Date 9 June 2022
Our Ref 22/00686/FLH

Town and Country Planning Act 1990 (As Amended)
1 Cumnor Gardens, Stoneleigh, Epsom
Part two/part single storey rear extension, two storey side extension and single storey front extension incorporating new entrance.

PROPOSED GROUND FLOOR PLAN

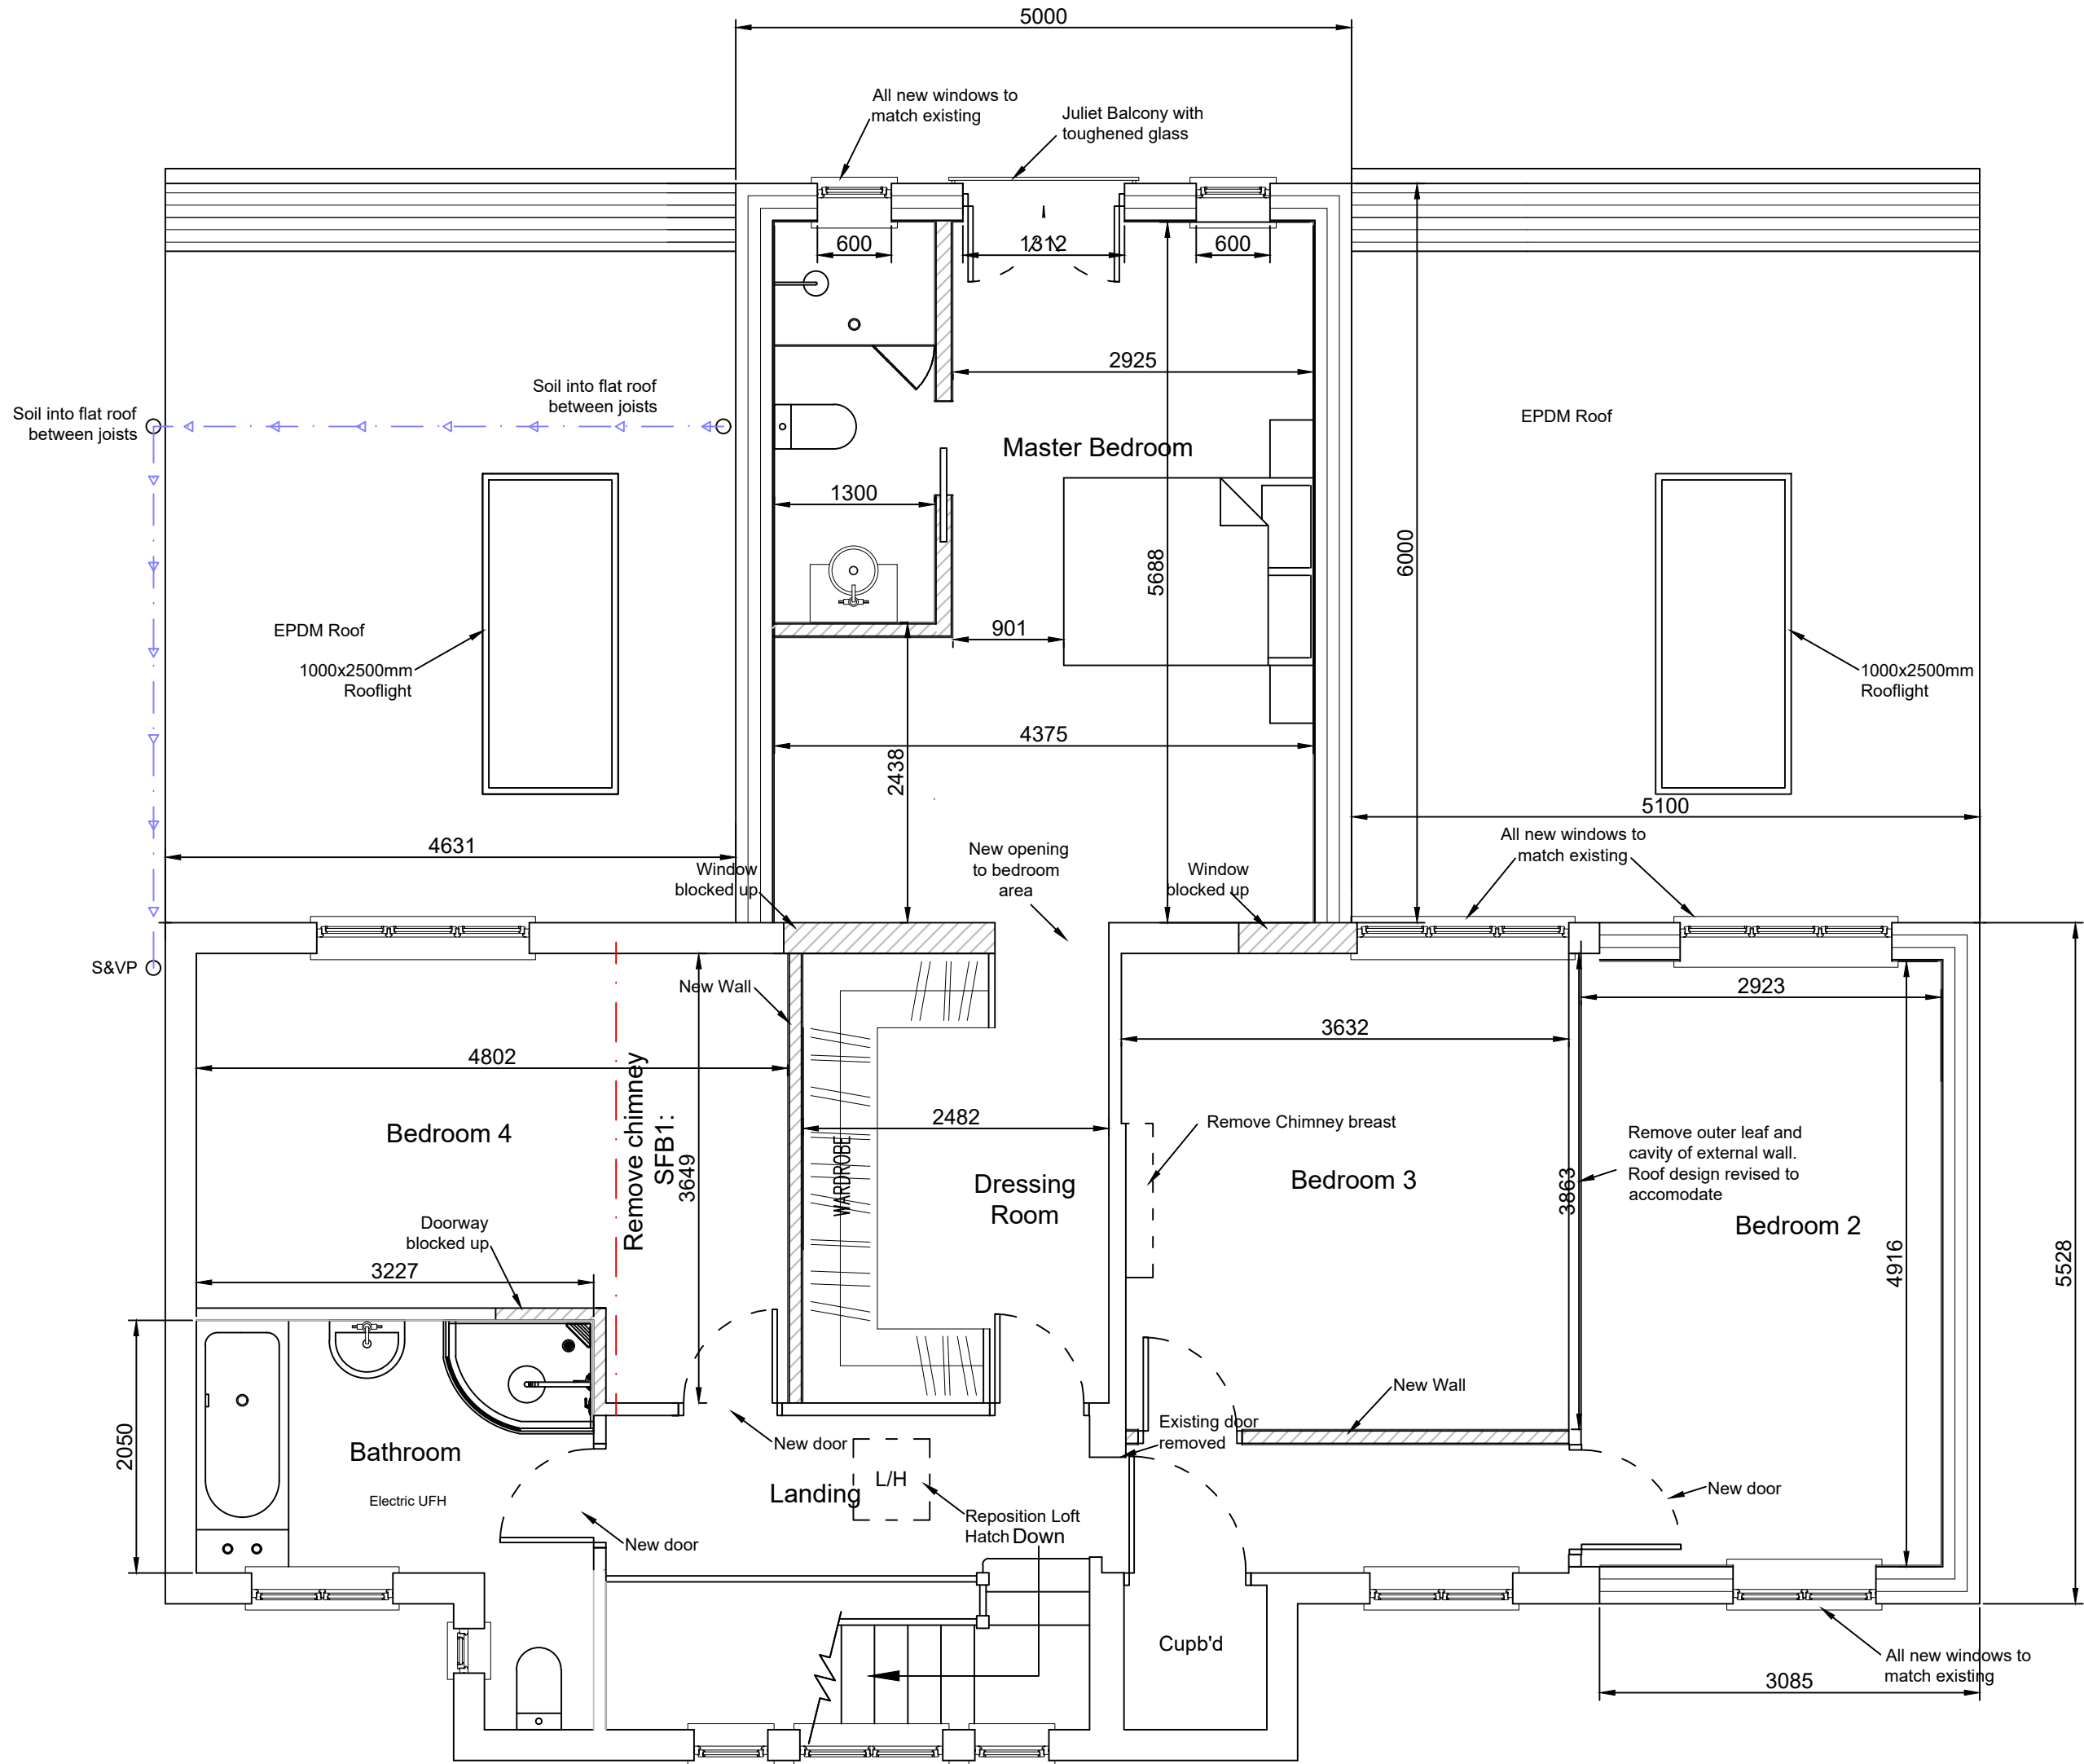
1 There are discrepancies on the footprint of the proposal, for example, the proposed single storey front extension features on the Proposed Ground Floor Plan and has been omitted from both the Proposed Site Plans (1:200 and 1:500). There are also discrepancies between the proposed south-western side elevation which is shown as a continuous line on the Proposed Floor Plans and Proposed Site Plan (1:200) but stepped on the Proposed Site Plan (1:500). The existing single storey front extension is also missing from both the Proposed Site plans. Please ensure that all plans match.
